WEST SUSSEX COUNTY COUNCIL CONSULTATION

TO:	Arun District Council FAO: Harry Chalk
FROM:	WSSC – Highways Authority
DATE:	3 March 2025
LOCATION:	7 Roman Acre, Littlehampton, BN17 7HN
SUBJECT:	LU/36/25/PL Construction of 1 No 3-bedroom self-build house (resubmission following LU/187/23/PL). This application is in CIL Zone 4 and is CIL Liable as a new dwelling.
DATE OF SITE VISIT:	n/a
RECOMMENDATION:	Advice

SITE PLAN 1:250

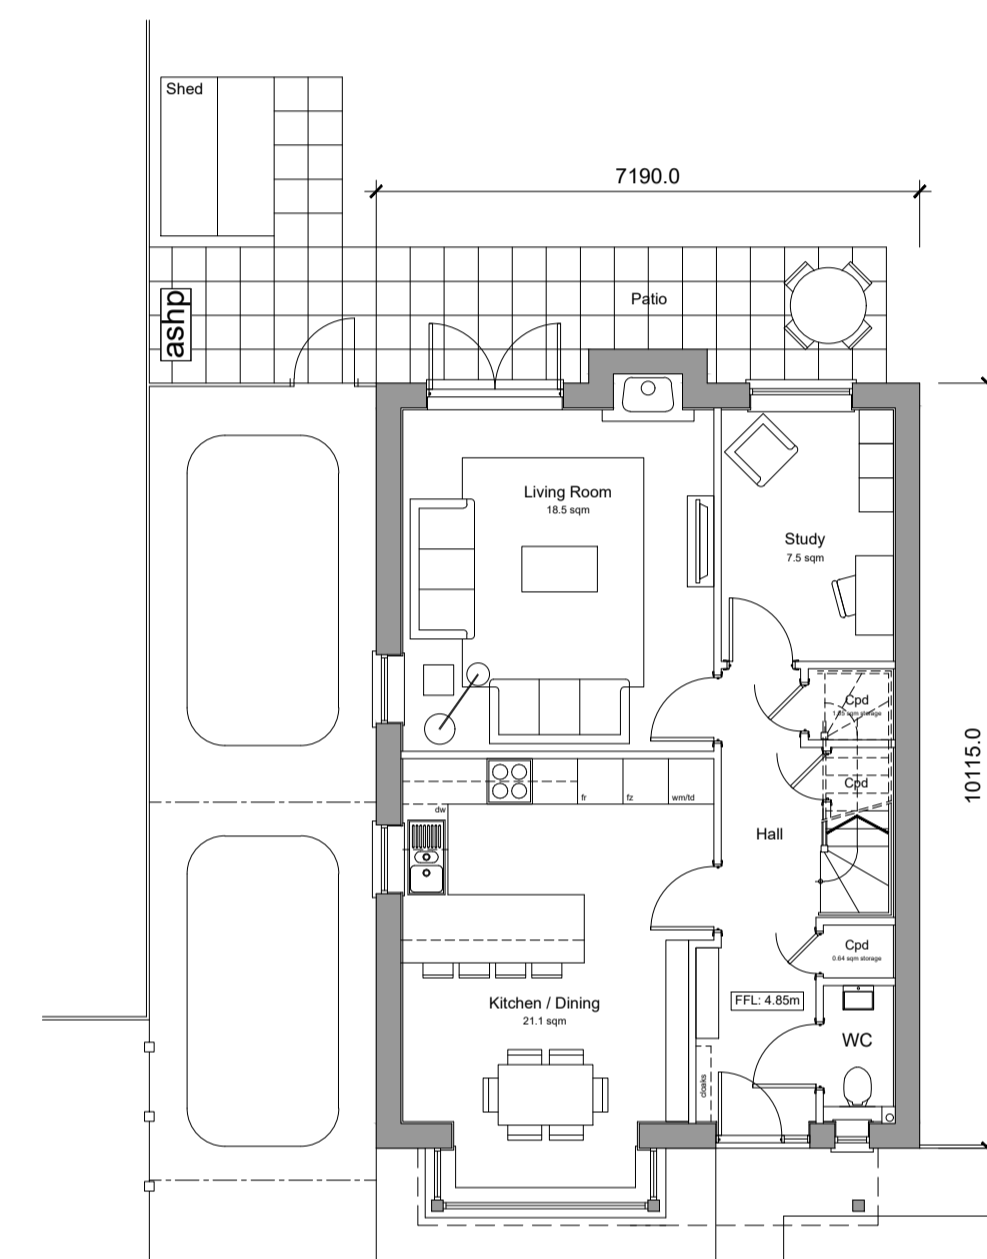
The applicant proposes two car parking spaces for the proposed dwelling and relocating one car parking space for the existing dwelling. For the proposed dwelling, to meet the Arun Car Parking Standards a dwelling of this size in this location would require at least three car parking spaces.

Therefore, any overspill parking associated with this development would have to be accommodated on-street. The LHA does not anticipate that the shortfall of one parking space would lead to a highway safety concern or parking capacity issue, but the LPA may wish to consider the potential amenity impacts.

From inspection of the plans, the proposed parking bays are suitably sized. The applicant has demonstrated a shed for each dwelling, which will provide secure cycle parking provision in accordance with Arun Parking Standards.

Car parking space (details approved)

No part of the development shall be first occupied until the car parking has been constructed in accordance with the approved site plan. These spaces shall thereafter be retained at all times for their designated purpose.
